WEST SUSSEX COUNTY COUNCIL CONSULTATION

TO:	Arun District Council FAO: Amber Willard
FROM:	WSCC – Highways Authority
DATE:	1 May 2025
LOCATION:	Land adjacent to 1 Elm Cottage Hook Lane Aldingbourne PO20 3TG
SUBJECT:	AL/30/25/OUT Outline application with some matters reserved (except access) for 2 No dwellings served from a new access in the location of the existing access. This application is a Departure from the Development Plan.
DATE OF SITE VISIT:	1 May 2025
RECOMMENDATION:	Advice

Drawing No.: 2024-6645-002 Rev.: B

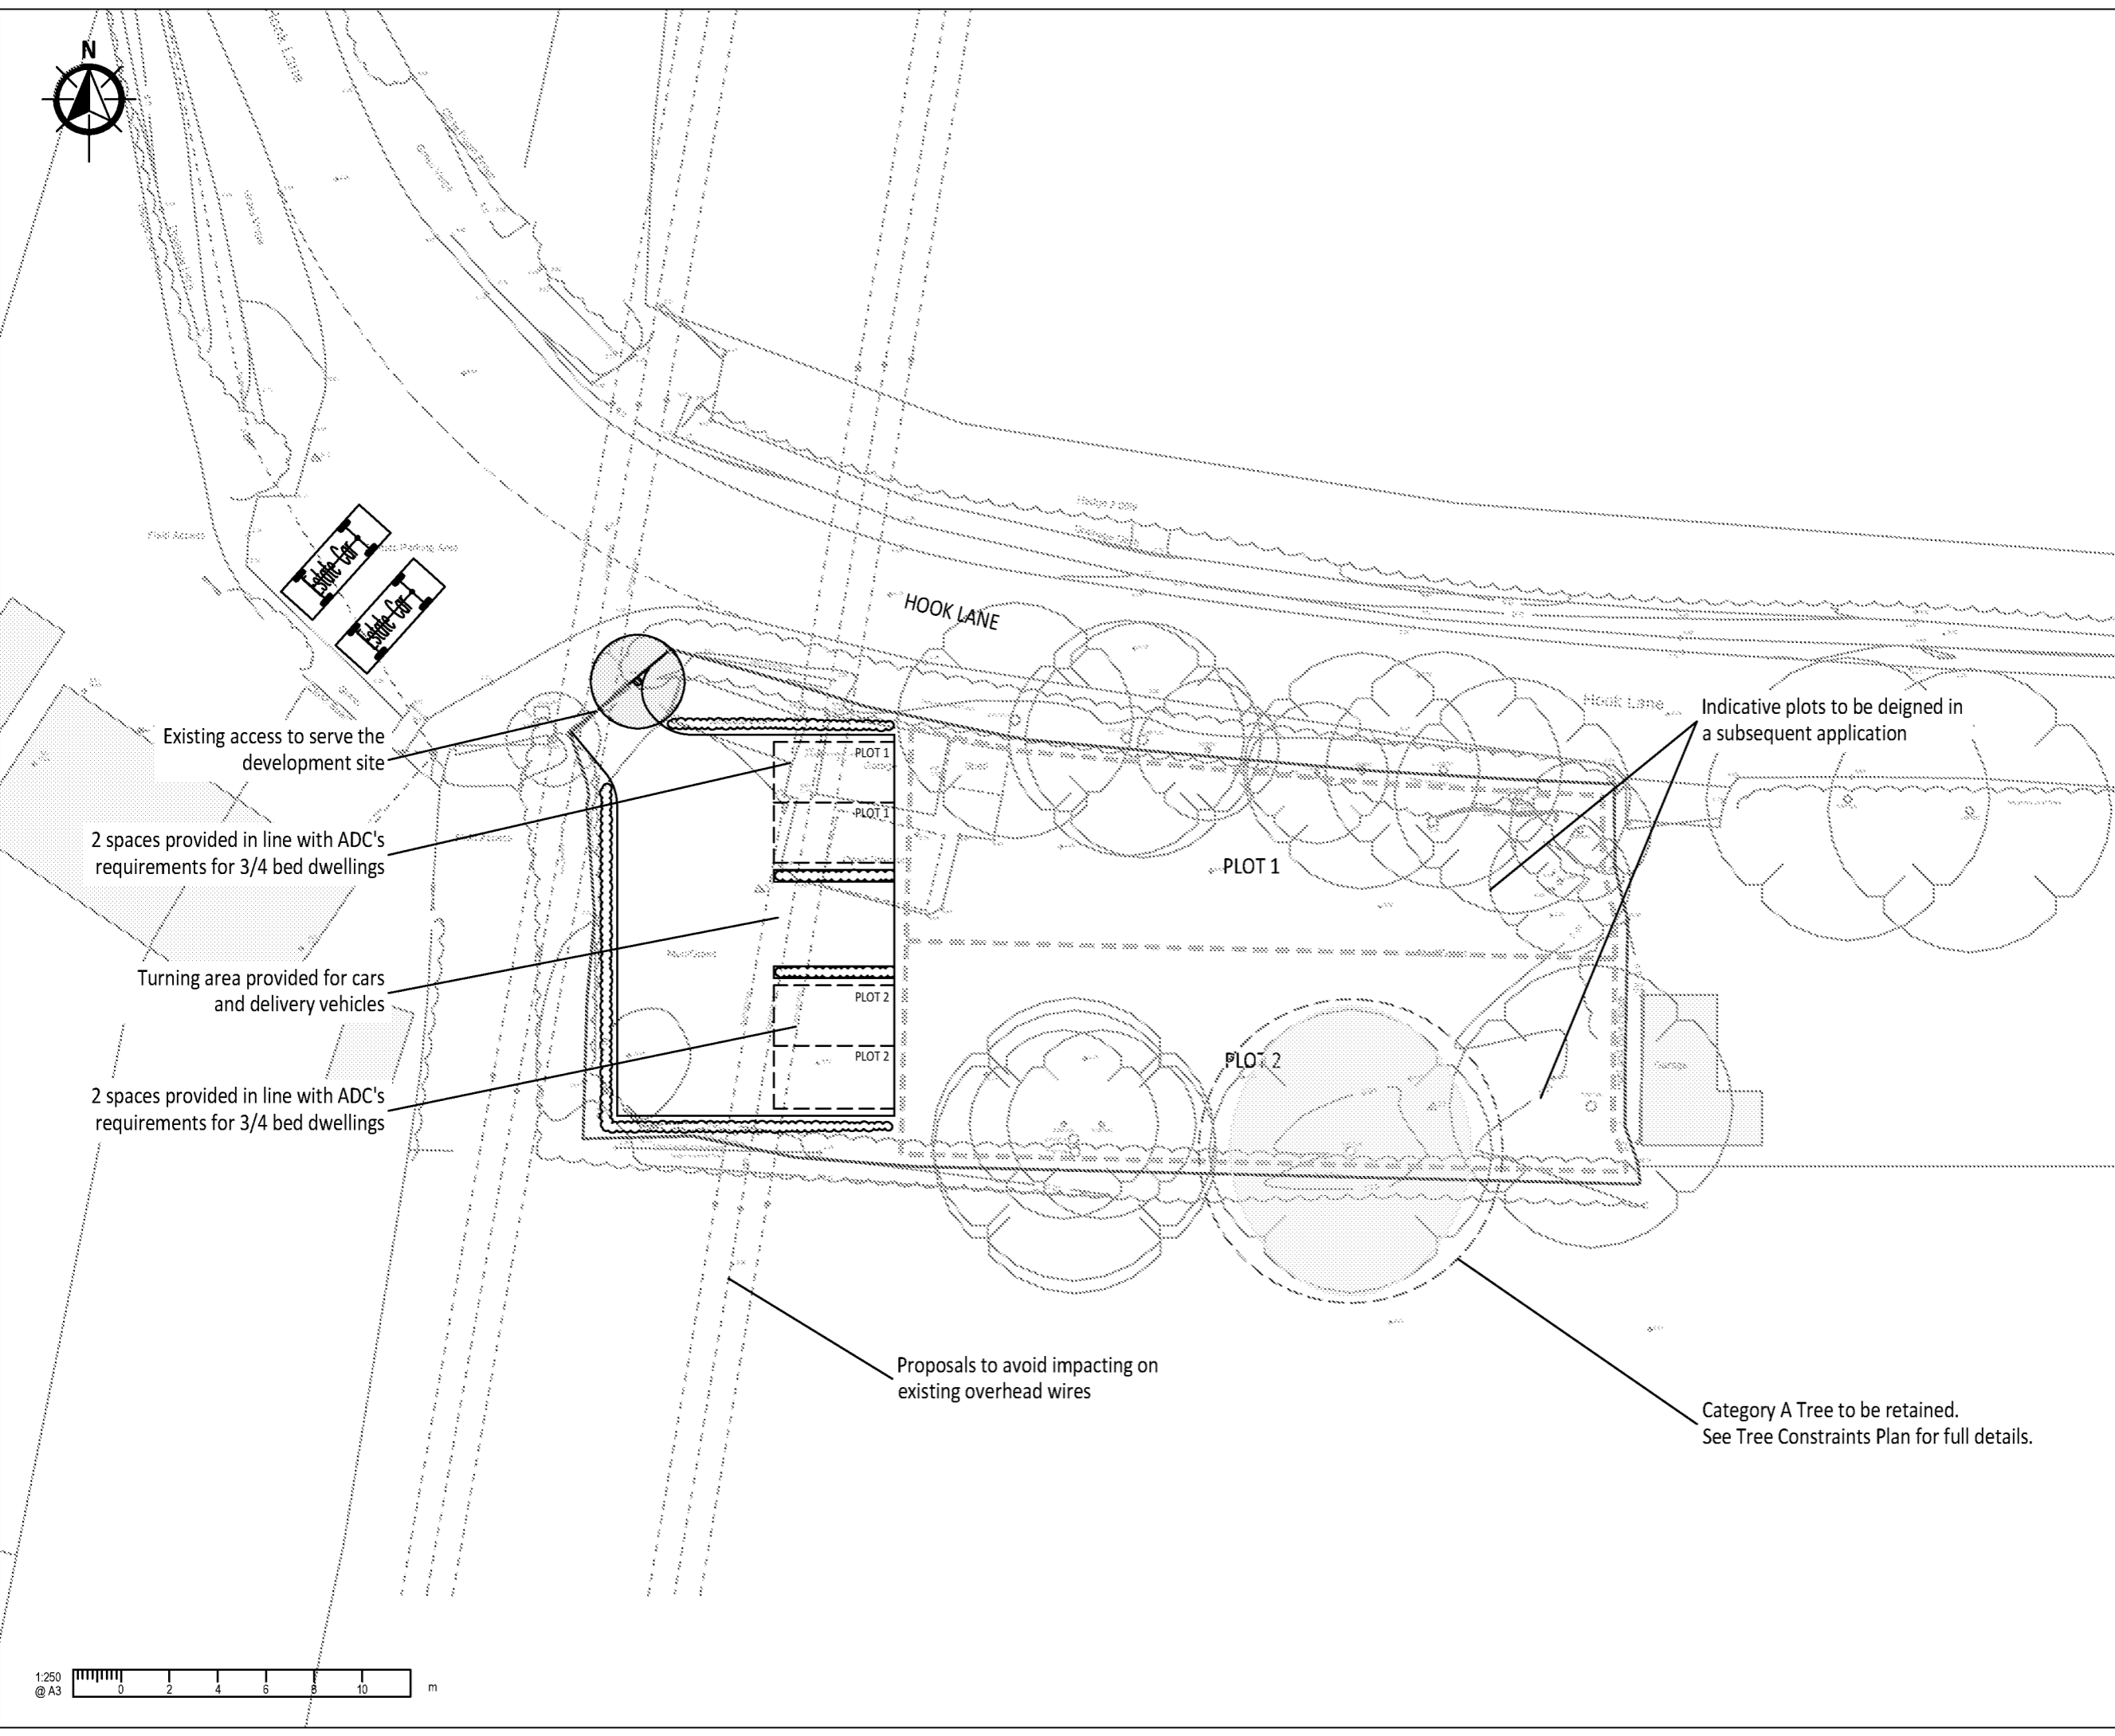
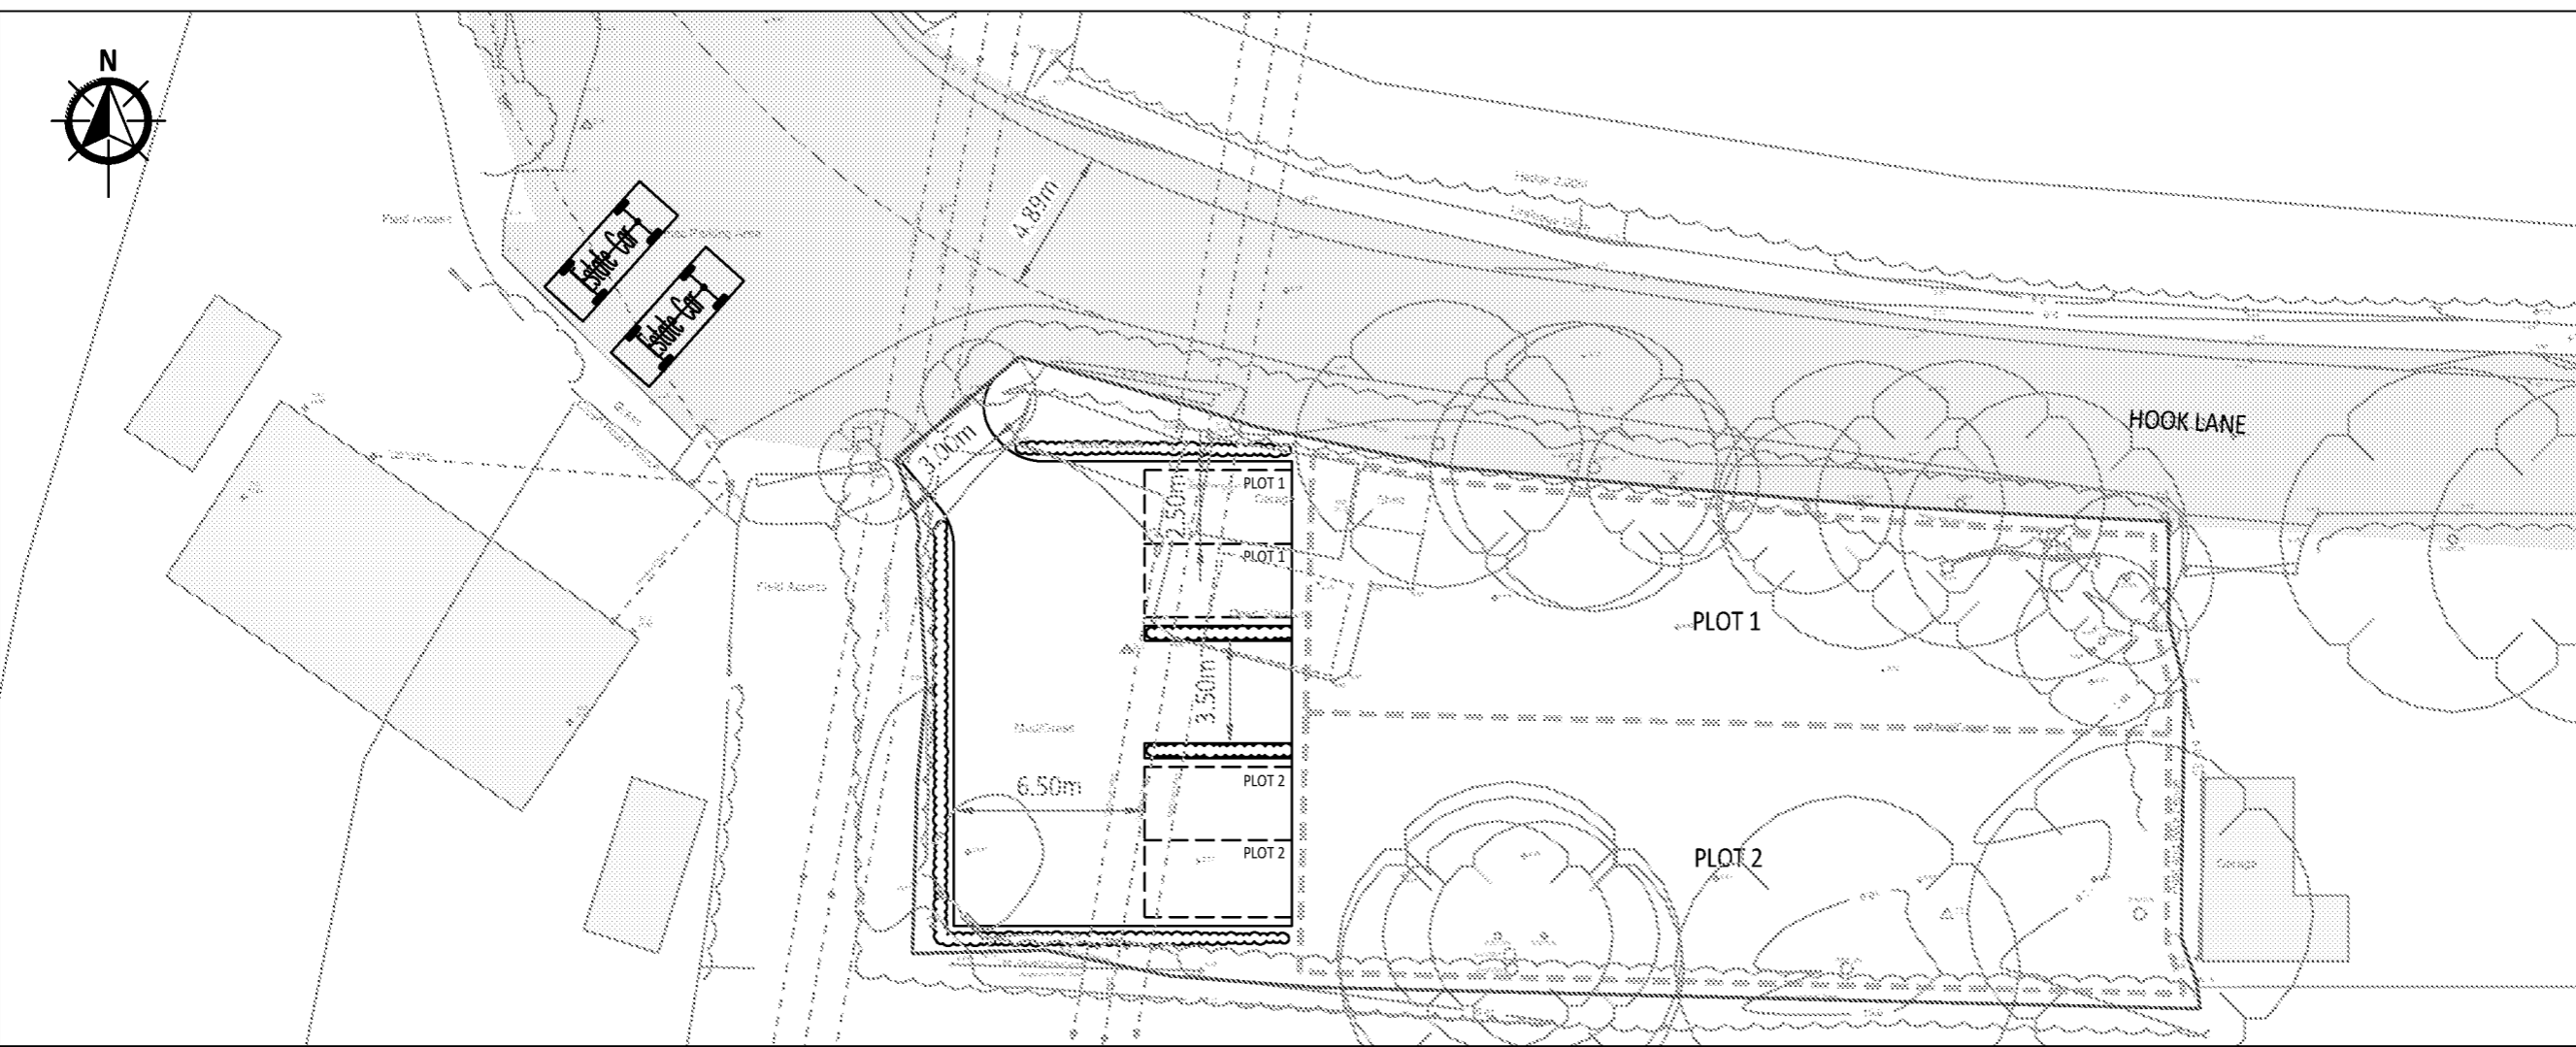
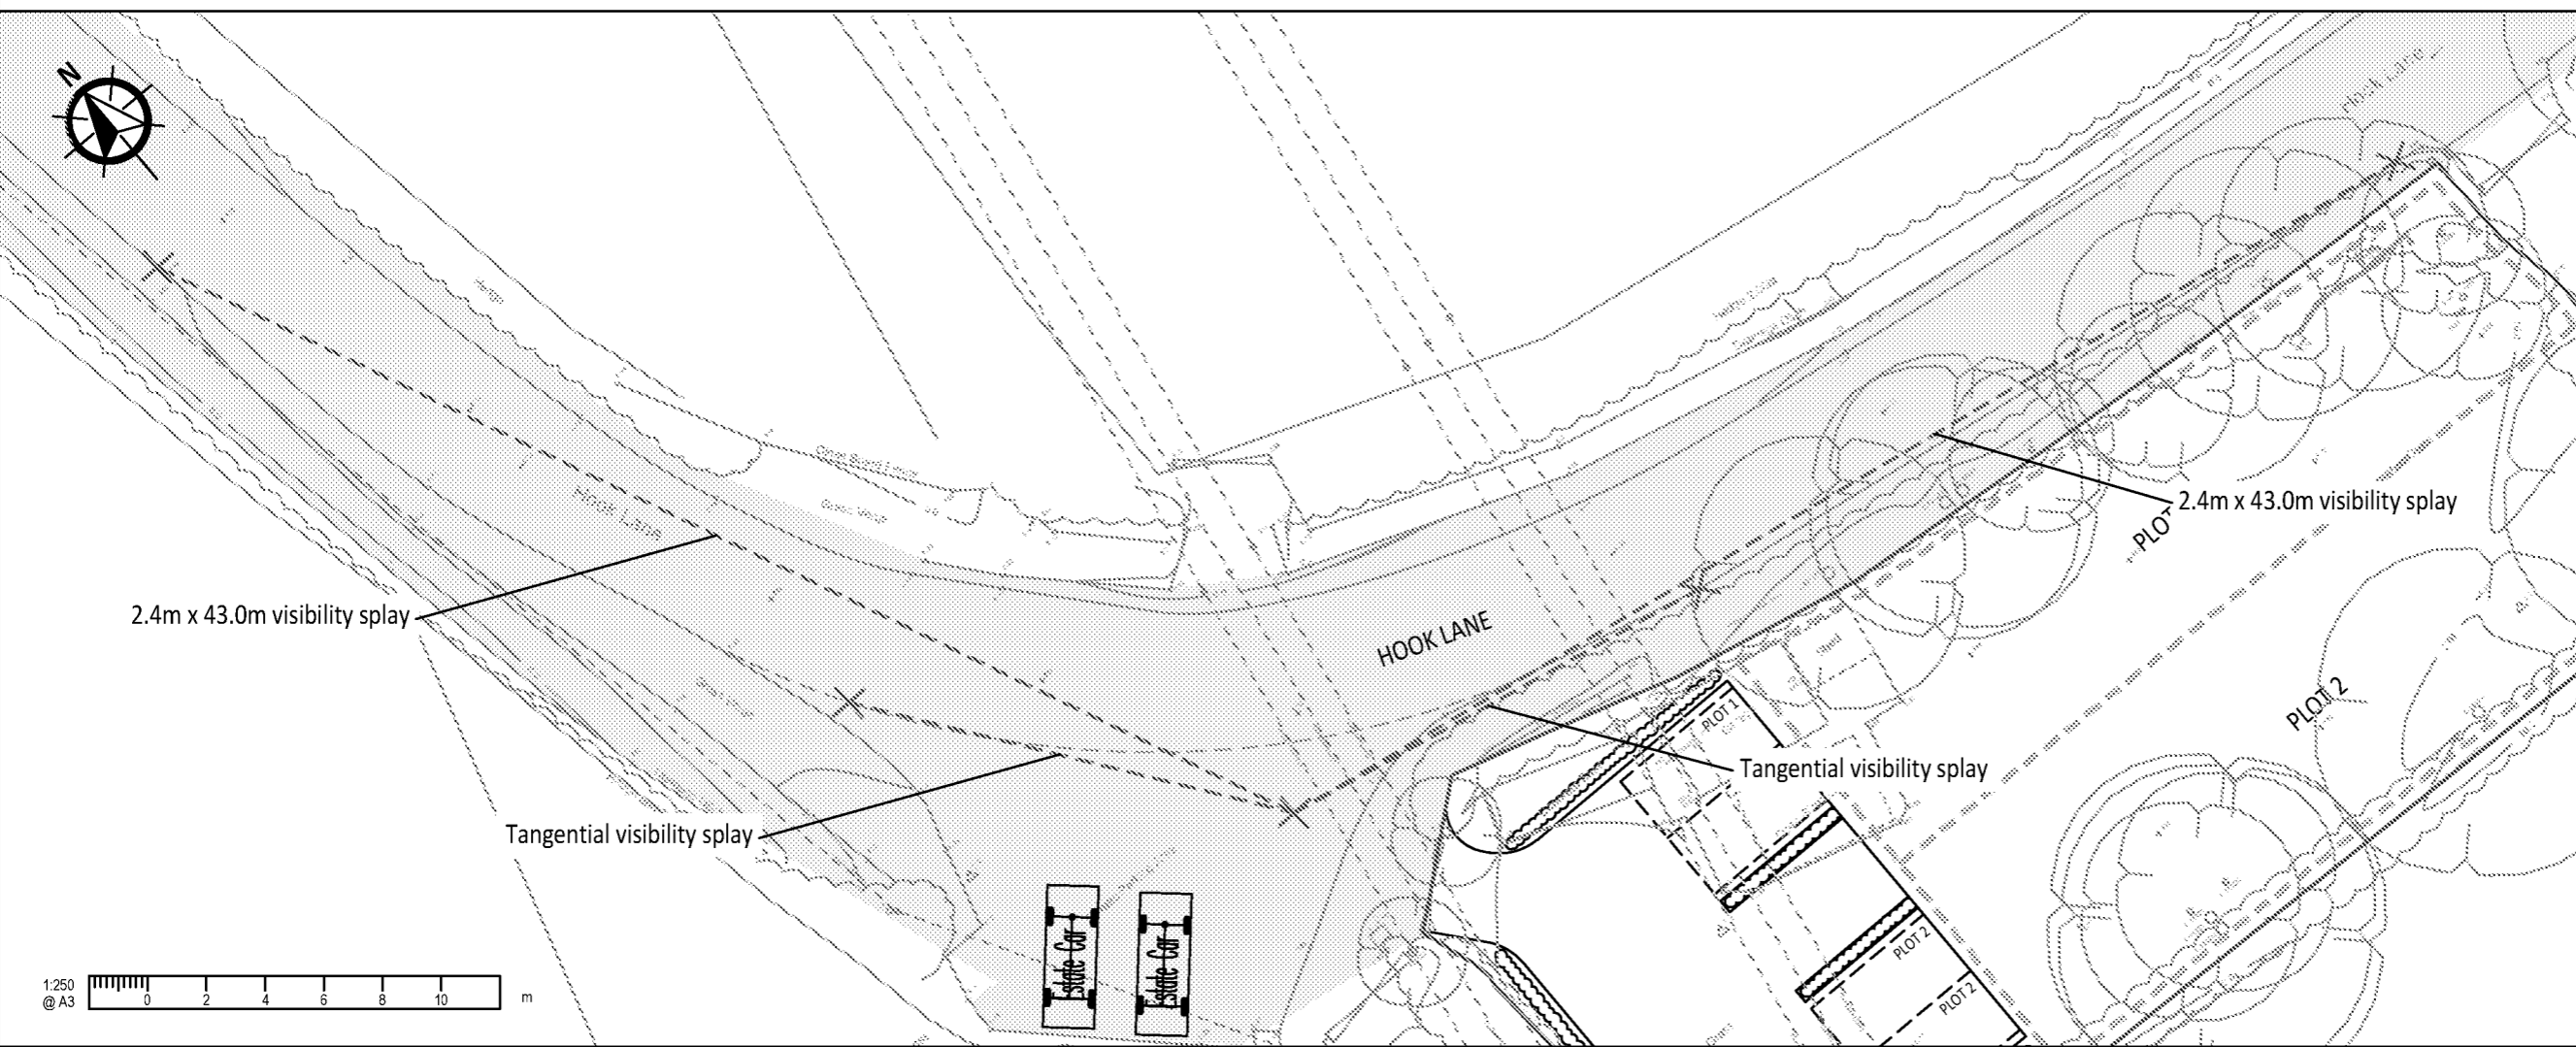
The Technical Note has demonstrated that from the access point of the unmade parking area, visibility splays of 2.4m x 43m are achievable in both directions onto Hook Lane. This visibility splay is in line with Manual for Streets requirements for a road subject to 30mph speed restrictions. The site benefits in positioning on the outside of a bend on Hook Lane which assists in facilitating the required visibility splay.

It was noted whilst on site that the splays are achievable from the centre of the parking area. However, as outlined within the TN would benefit from maintenance of the adjoining hedgerow and planting along the highway edge to the eastern direction. This should be maintained to a height of below 0.6m where under the ownership of the applicant. This will ensure that the splays are achievable for a driver waiting to egress onto the highway. The LHA advise a suitably worded condition to be sealed alongside any permission of this proposal, this will ensure the visibility splays are maintained in perpetuity.

No part of the development shall be first occupied until visibility splays of 2.4 metres by 43 metres have been provided at the proposed site vehicular access onto Hook Lane in accordance with the approved planning drawings. Once provided the splays shall thereafter be maintained and kept free of all obstructions over a height of 0.6 metre above adjoining carriageway level or as otherwise agreed.
